Town & Country Planning Act 1990 (as amended)
Town and Country Planning (Development Management Procedure) (England) Order 2010 (as amended)
Application for Planning Permission

Development Internal alterations to change use of first and second floors from residential (Class C3) to Retail (Class A1). This application affects the Character and Appearance of the Arundel Conservation Area.

Location 39 High Street Arundel

A	14.04.01	Road names added.	JB	-
rev.	date	comment	auth.	chkd.
drawn JB	checked CR	work stage C	drawing title OS Extracts	drawing number 3481.PL.02
date Mar 2014	scale/sheet size var@A3	PLANNING	revision A

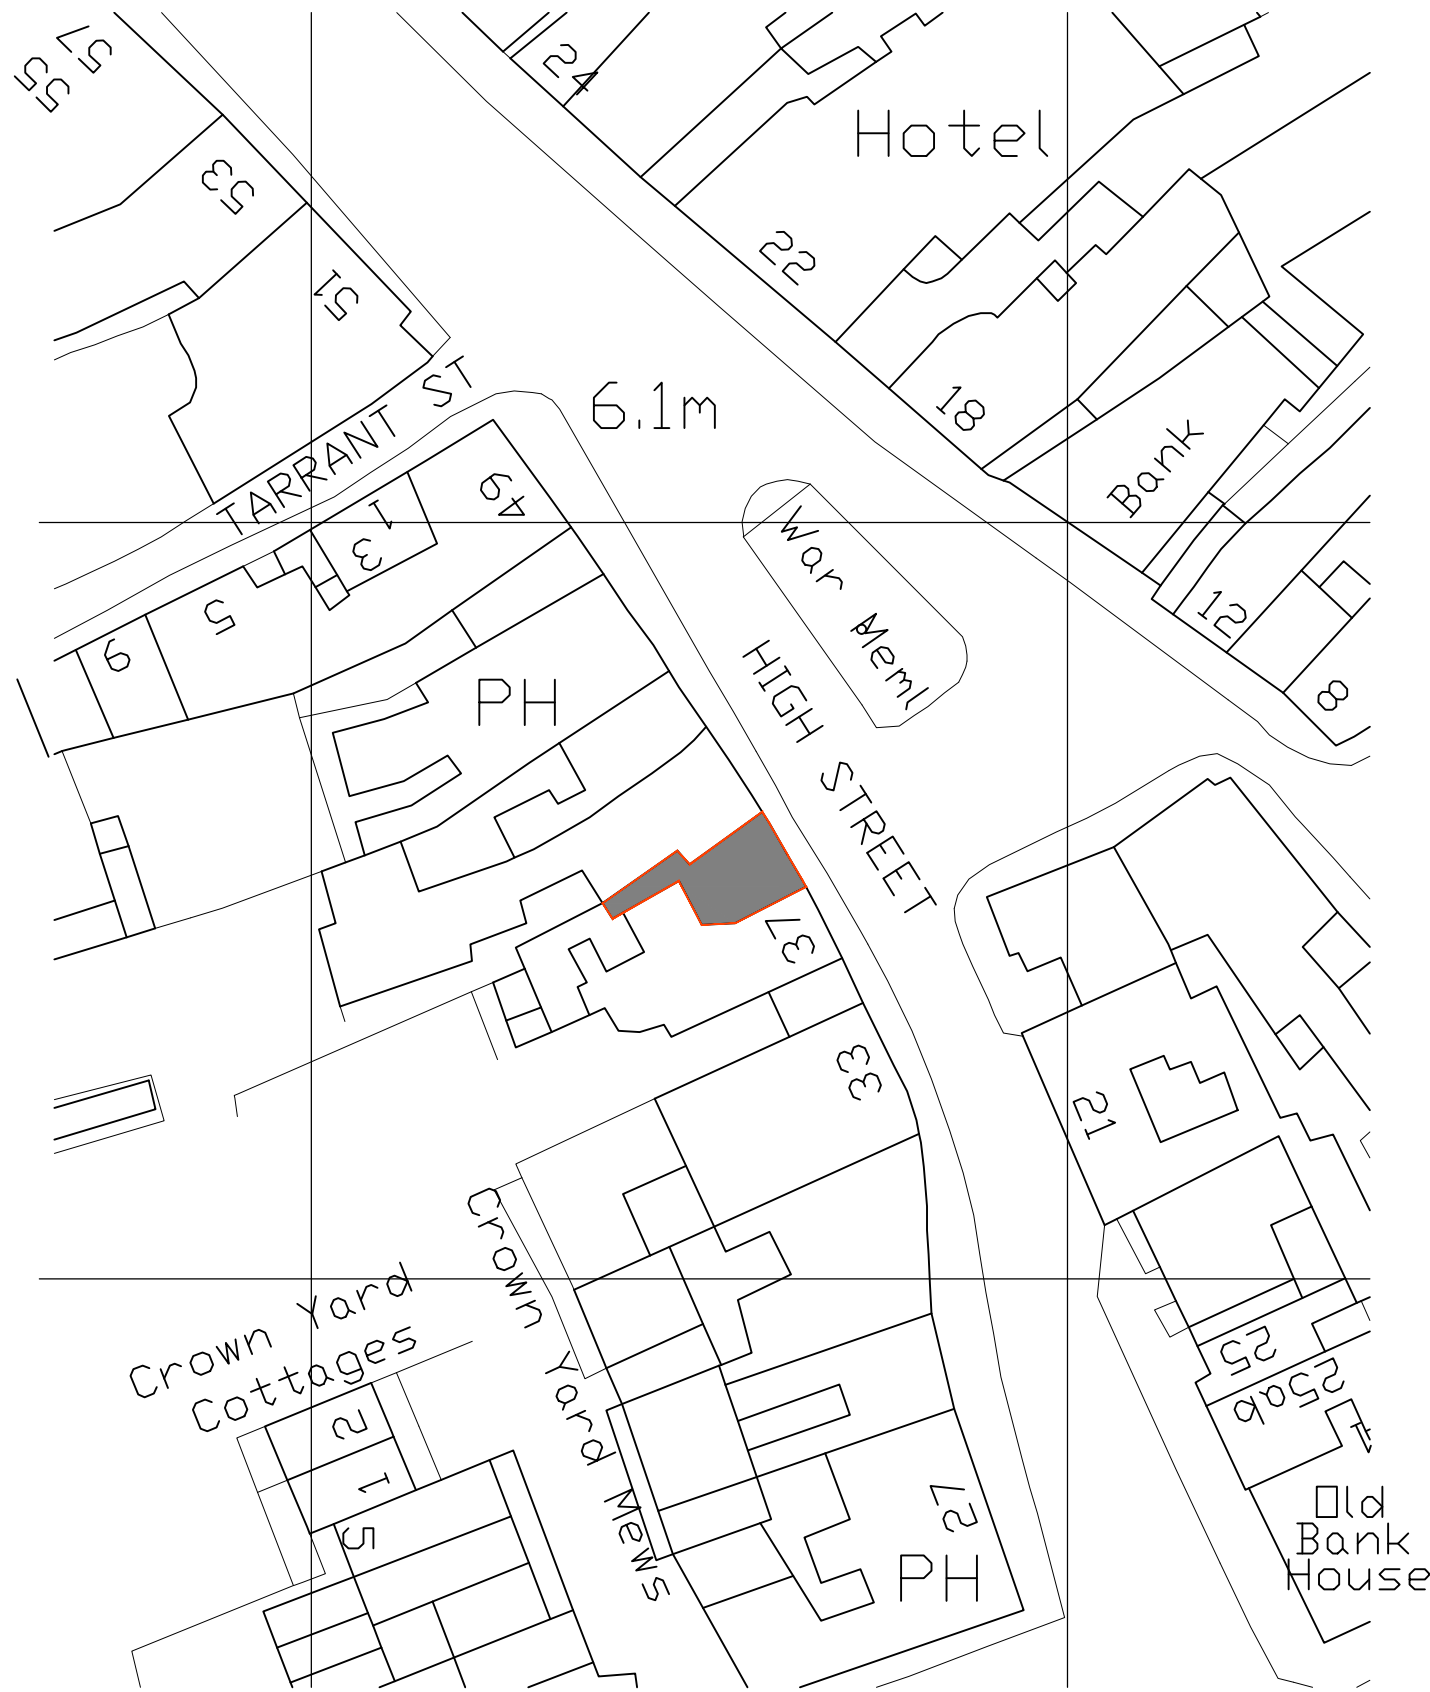
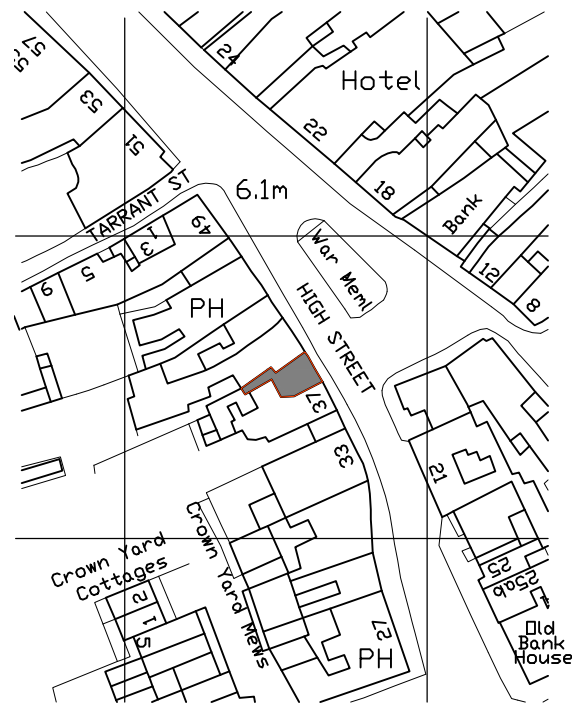
Location Plan

Please submit 1 electronic or 3 paper copies of an amended location plan at a scale of 1:1250 or 1:2500 for rural areas, to include 2 road names. Further details of what must be included on the plan can be found in the National Validation Requirements.

Block Plan

Please submit 1 electronic or 3 paper copies of an amended block/site plan at a scale of 1:500 or 1:200, to include a road name. Further details of what must be included on the plan can be found in the National Validation Requirements.
